Our ref: HE548643-ARC-GEN-A585-LE-ZM-4044

**A585 Windy Harbour to Skippool Improvement Scheme ("the Scheme")**

The proposed changes are shown on the enclosed drawing (HE548643-ARC-LLO-SZ\_ZZ000DR-D-3036).

Client
 Project A585 WINDY HARBOUR TO SKIPPOOL IMPROVEMENT SCHEME
 Drawing Title DESIGN CHANGE 2 RYECROFT FARM ACCESS LAND AND WORKS

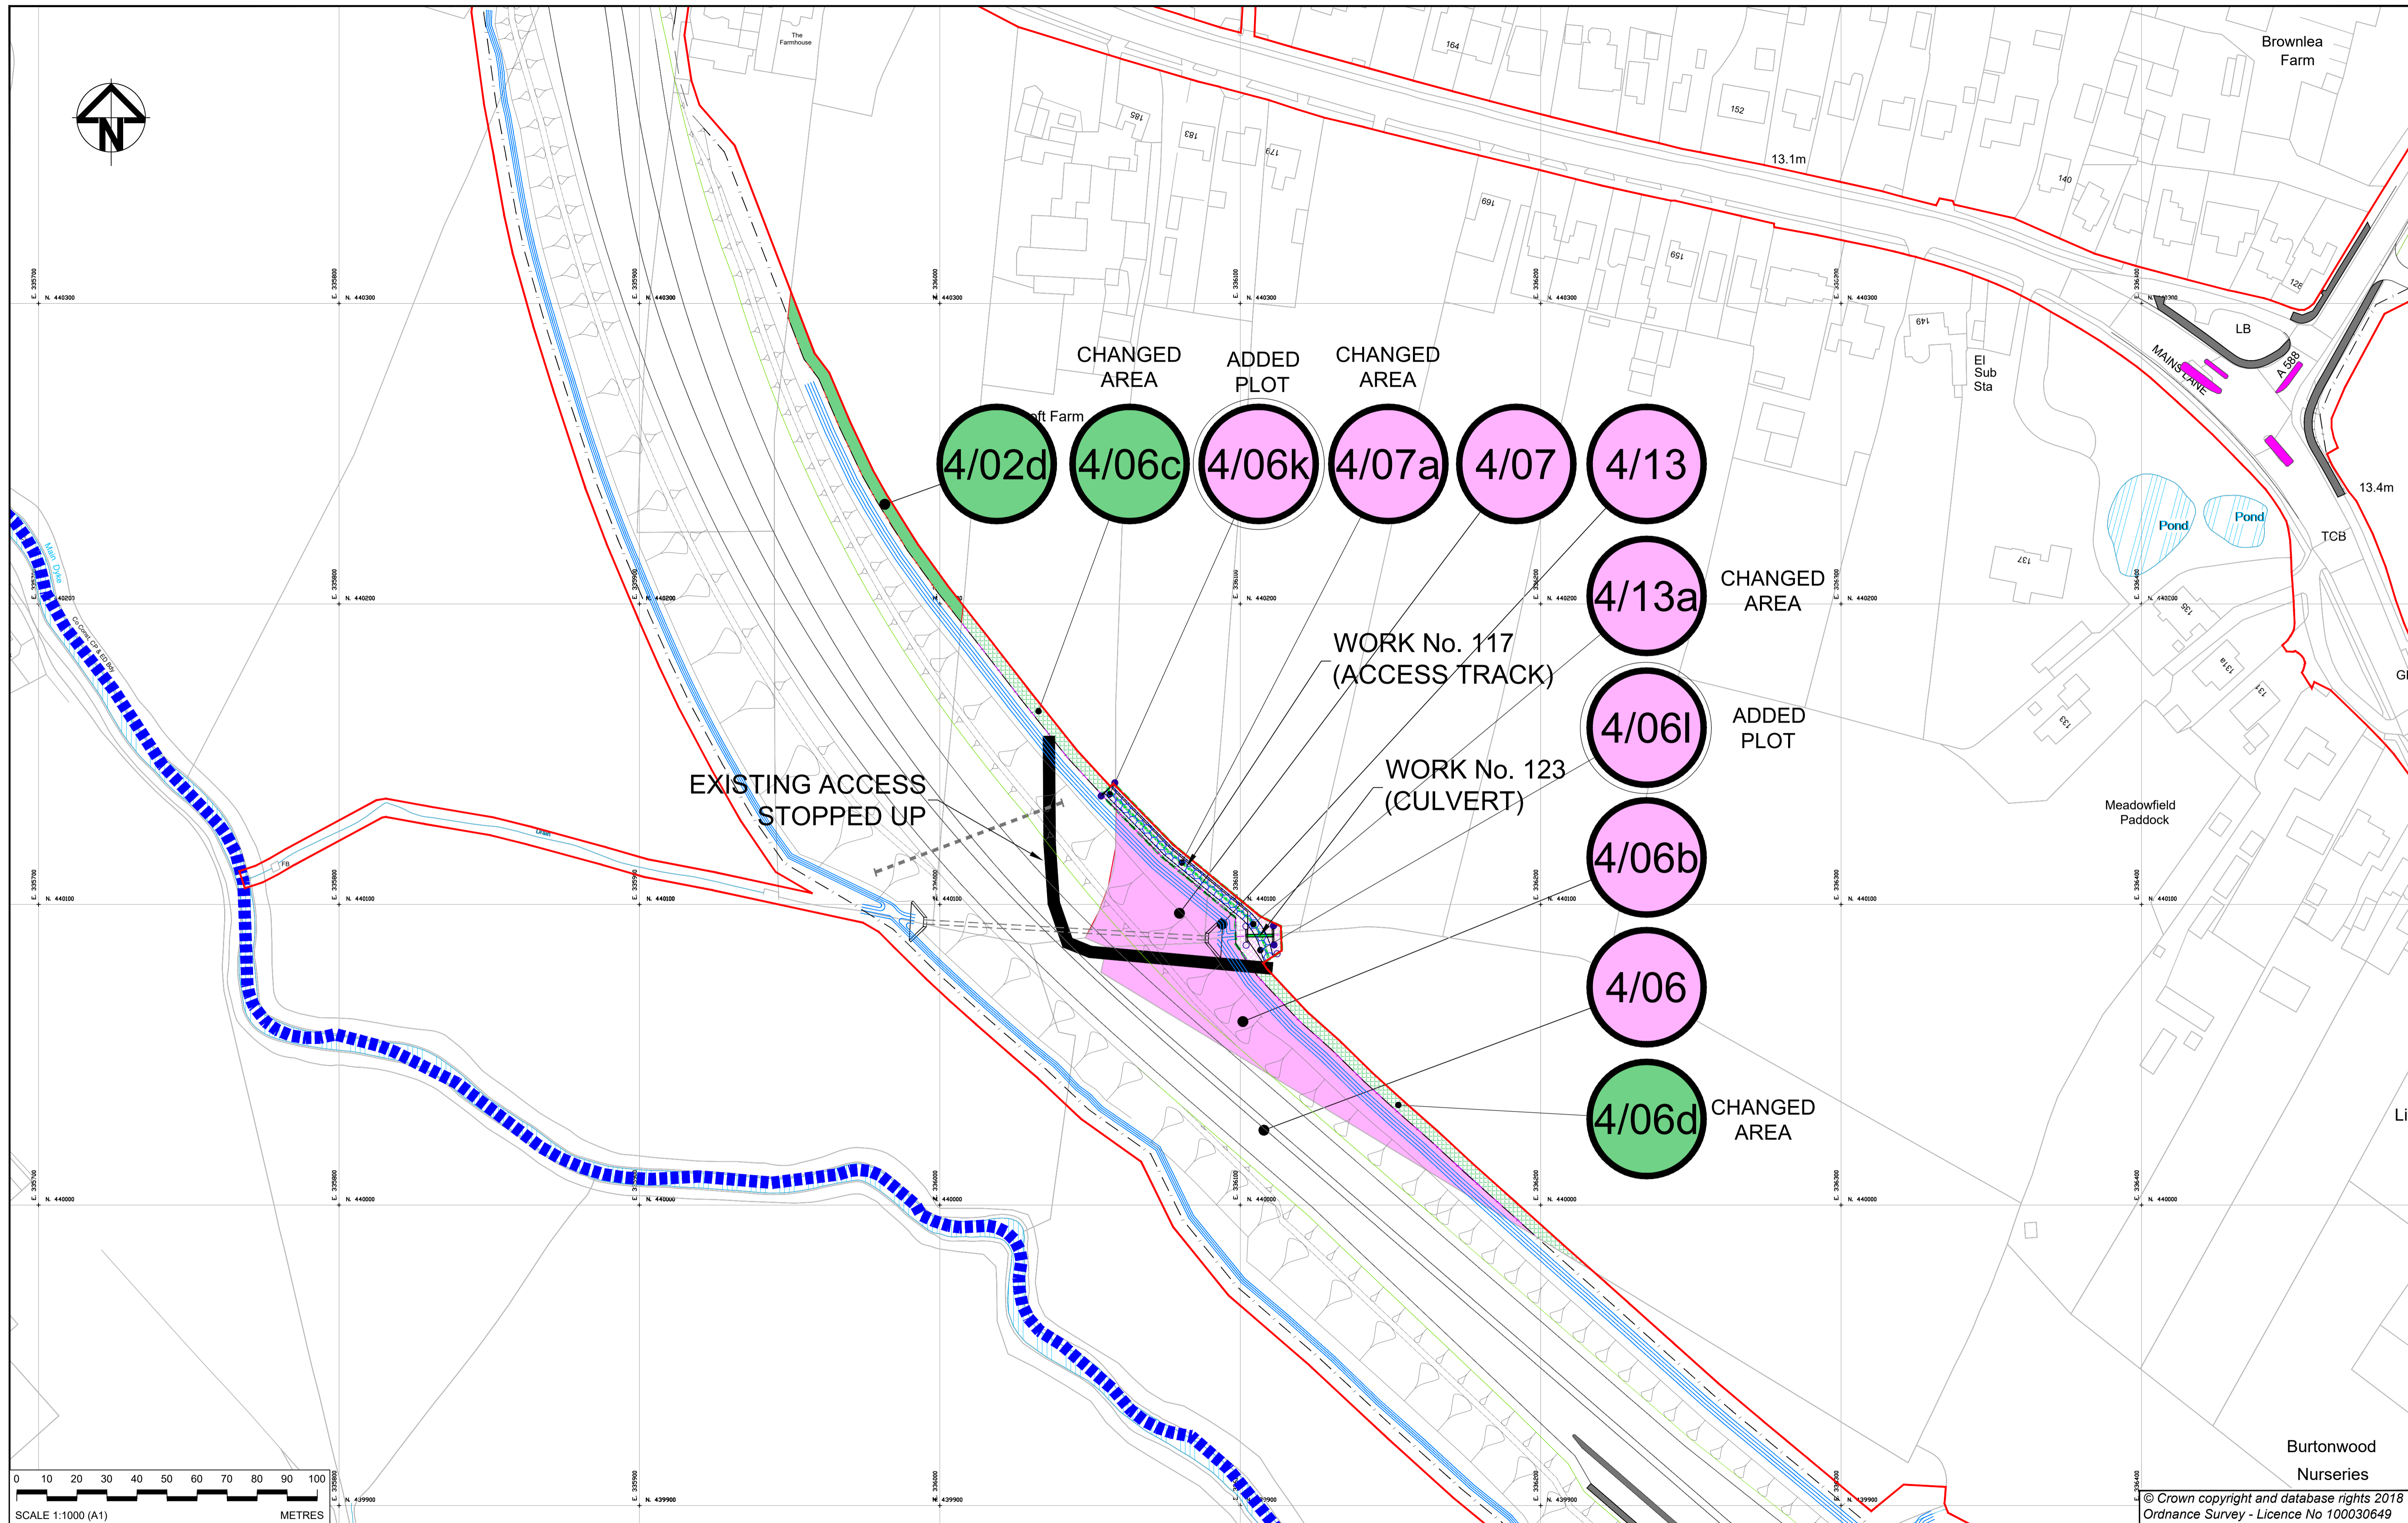
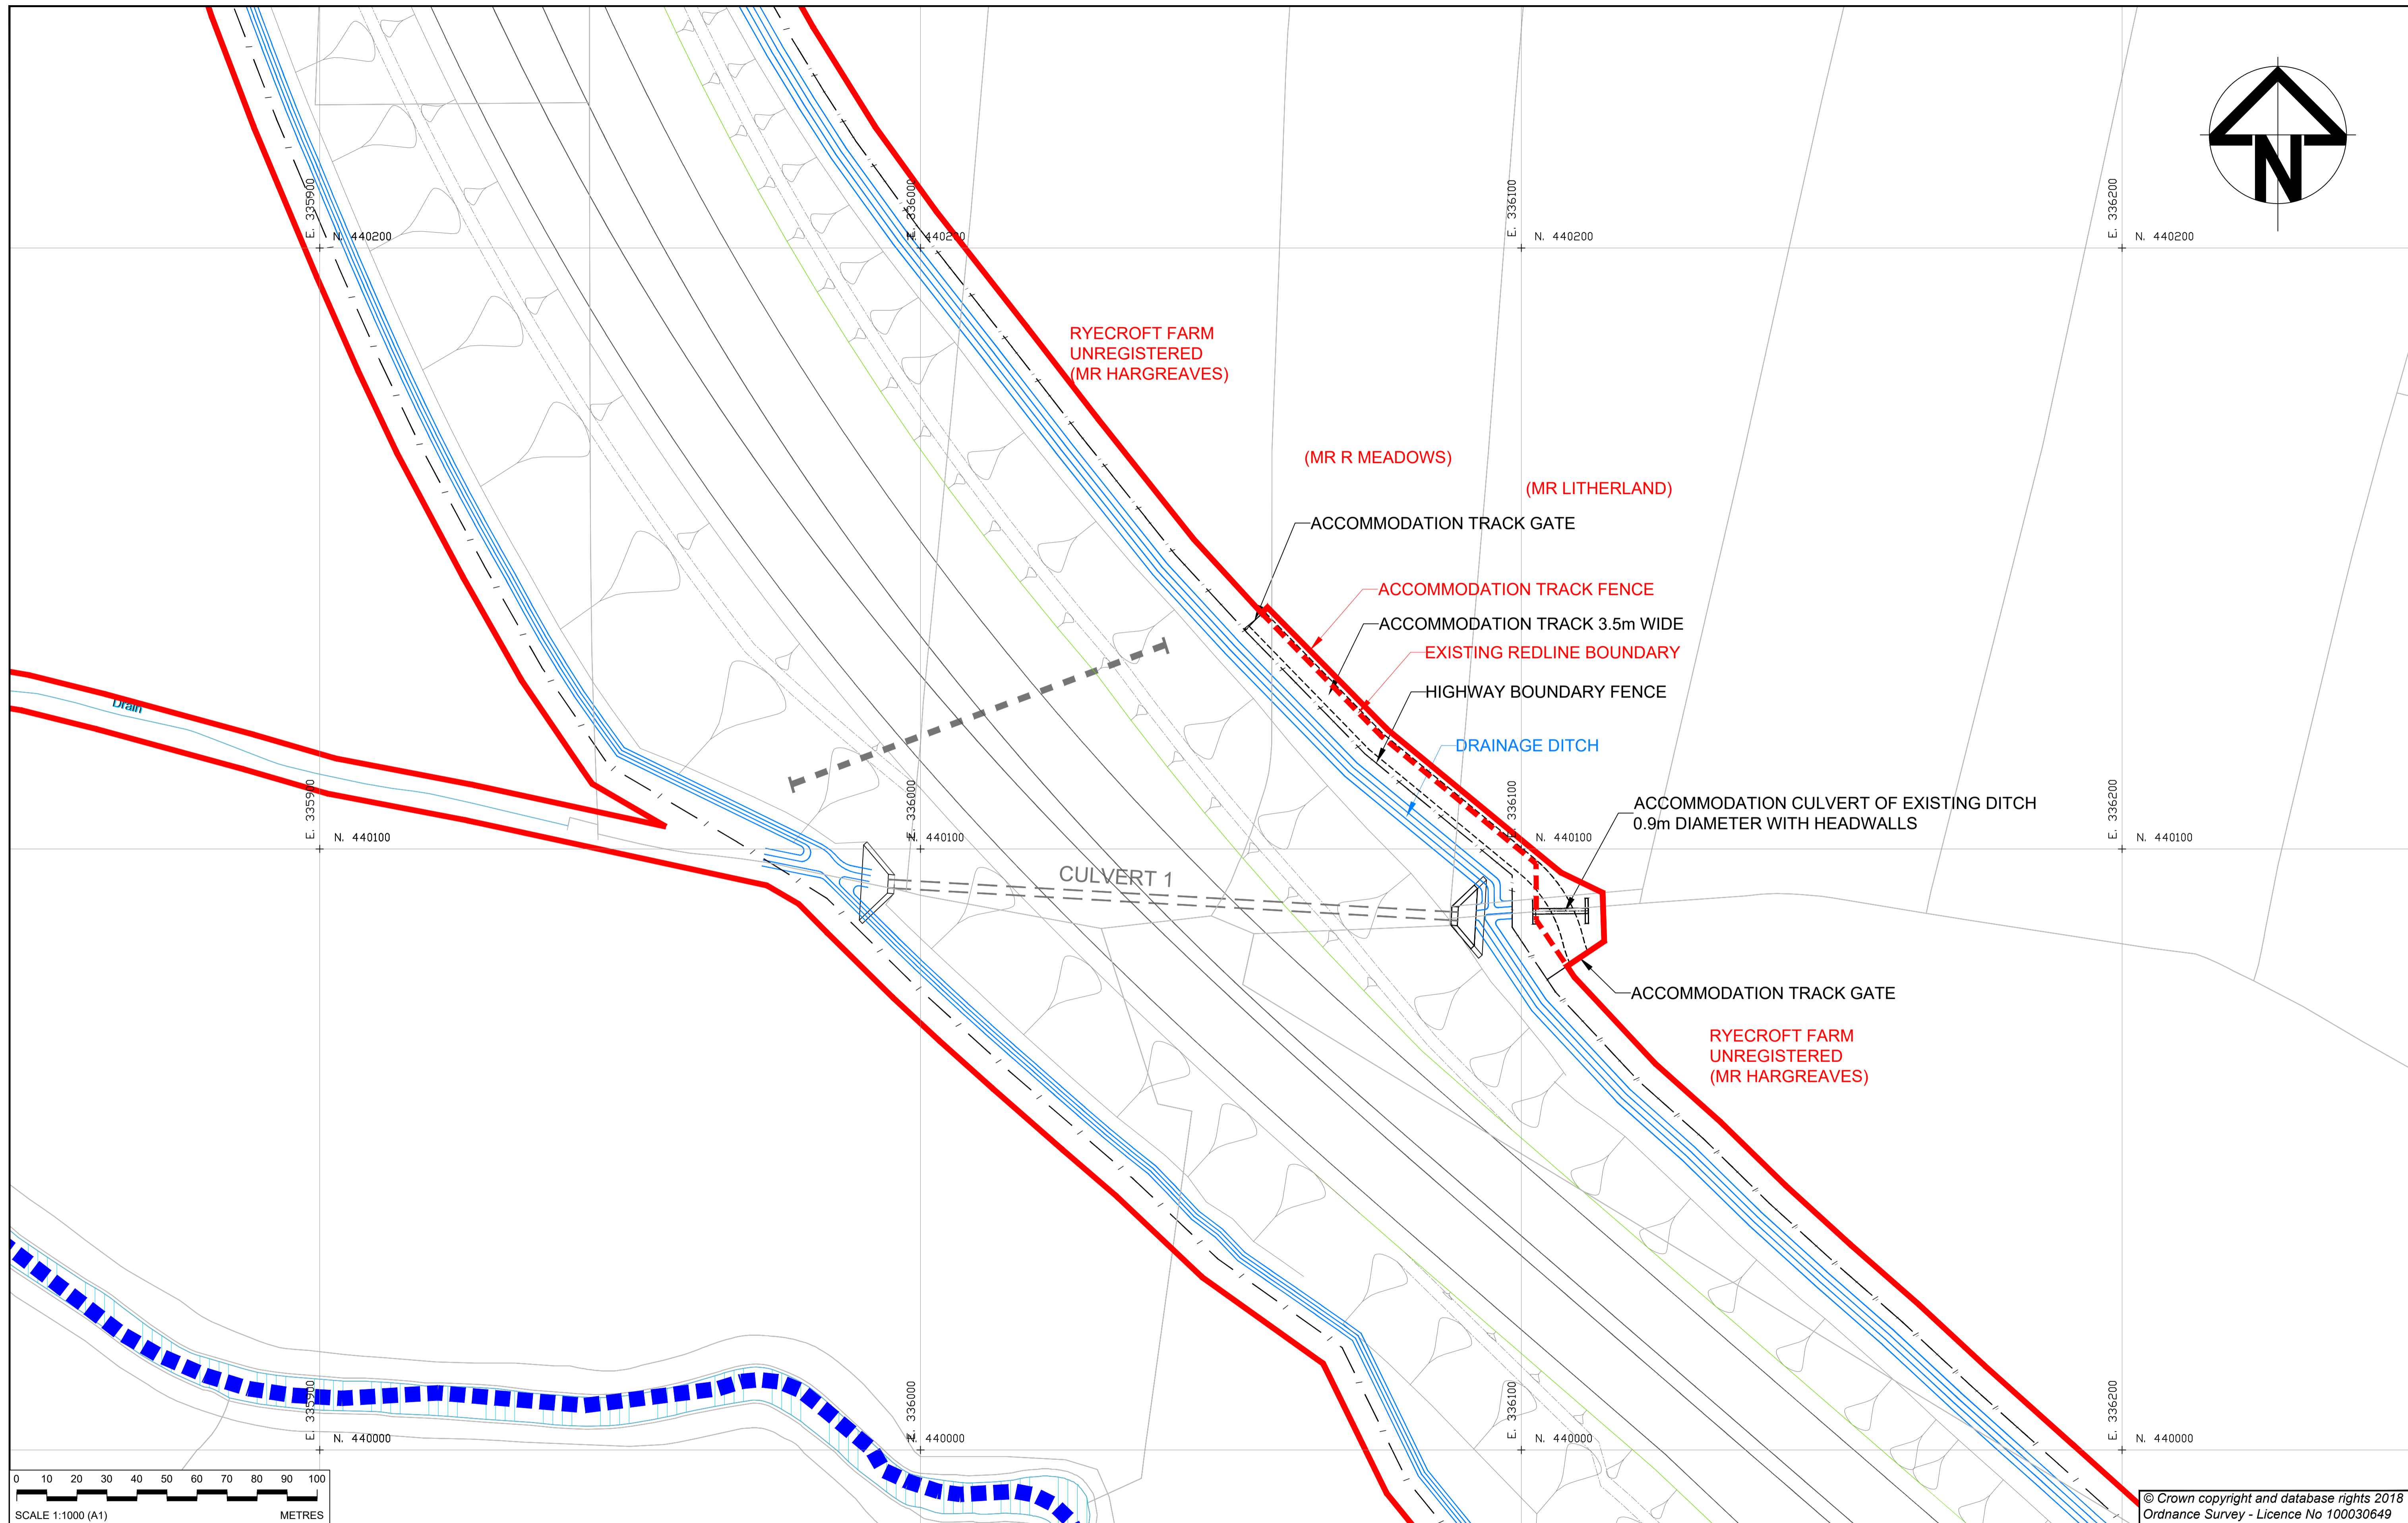
Following your request that your plots of land to the north of the Scheme remain connected once the bypass is constructed, Highways England is proposing to make various changes to the Scheme within the vicinity of your land, including:

- Provision of a link to the main farm land with the plot to the north-east of Culvert 1 as the bypass severs the northern land parcel
- Construction of a farm access track 3.5m wide within a nominal width of 5.5m
- Provision of accommodation fencing on the north side of the access track
- Provision of farm gates at both ends of the access track
- Provision of an accommodation culvert (0.9 metre diameter) across the ditch to the north-east of Culvert 1

You will see that, in order to carry out the changes, Highways England will need to change the extent of the land acquired from you as follows:

Plot	Current Proposal	Proposed Change
4/06c	Temporary Possession	Reduce area by 18 square metres
4/06k	Permanent Acquisition	New plot for access track comprising 22 square metres
4/06l	Permanent Acquisition	New plot for access track comprising 122 square metres
4/06d	Temporary Possession	Reduce area by 46 square metres
